Town & Country Planning Act 1990 (as amended)
Town & Country Planning (Development Management Procedure) (England) Order 2015
Application for Planning Permission for Works or Extension to a Dwelling

Development Single storey front and side extension, raised flat roof , vehicular crossover and new render to front elevation.

Location 29 Mallon Dene Rustington

Site and Block Plan Plan.
 Ref: SBS/532/07 A

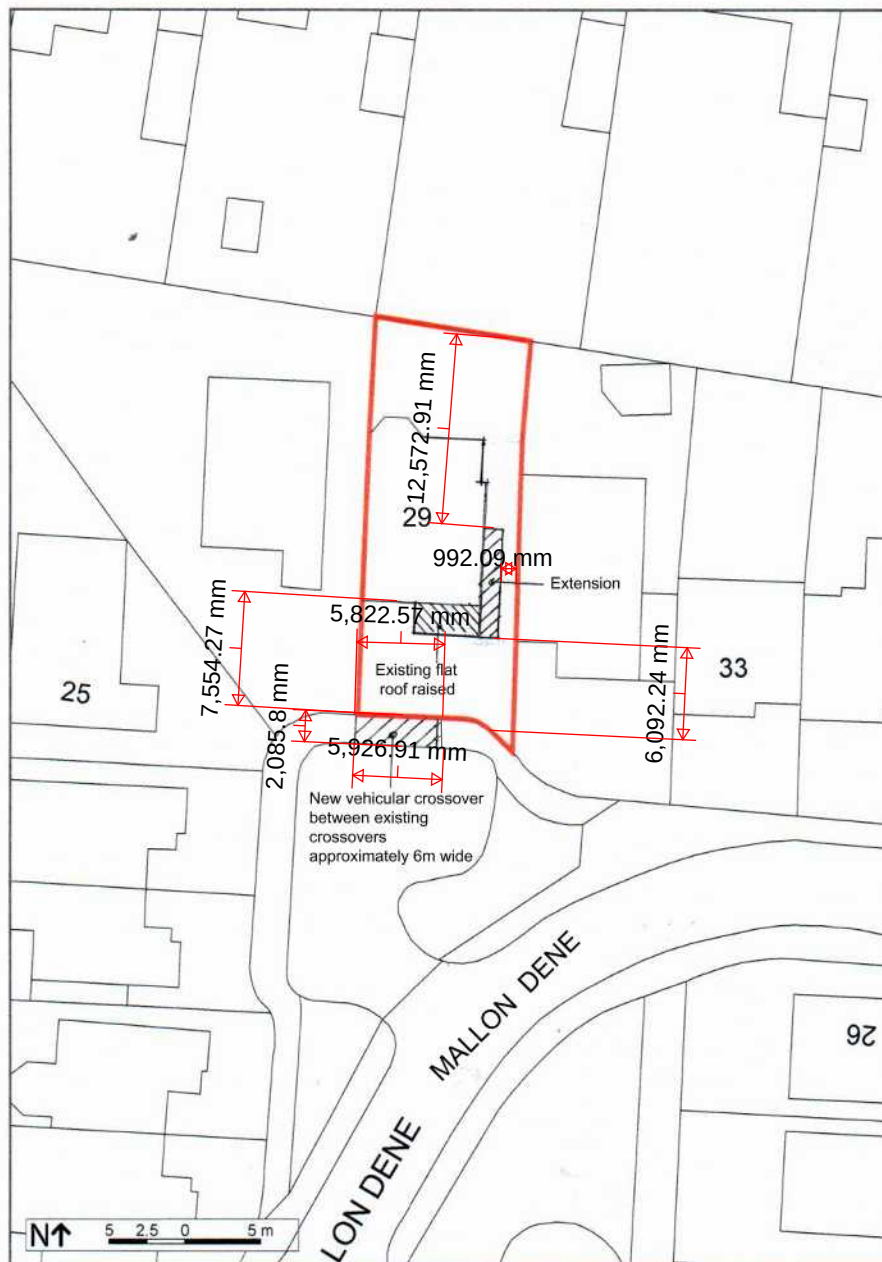
Block Plan

Please include dimensions on the block plan for the proposed crossover.

Splay Plan Required: A visibility splay is formed by measuring to a point 2.4m back from the carriageway in the centre of the driveway or entrance. A line (70m long in the case of a 30mph limit) is then drawn to the right, to a point where it strikes the near-side edge of the carriageway
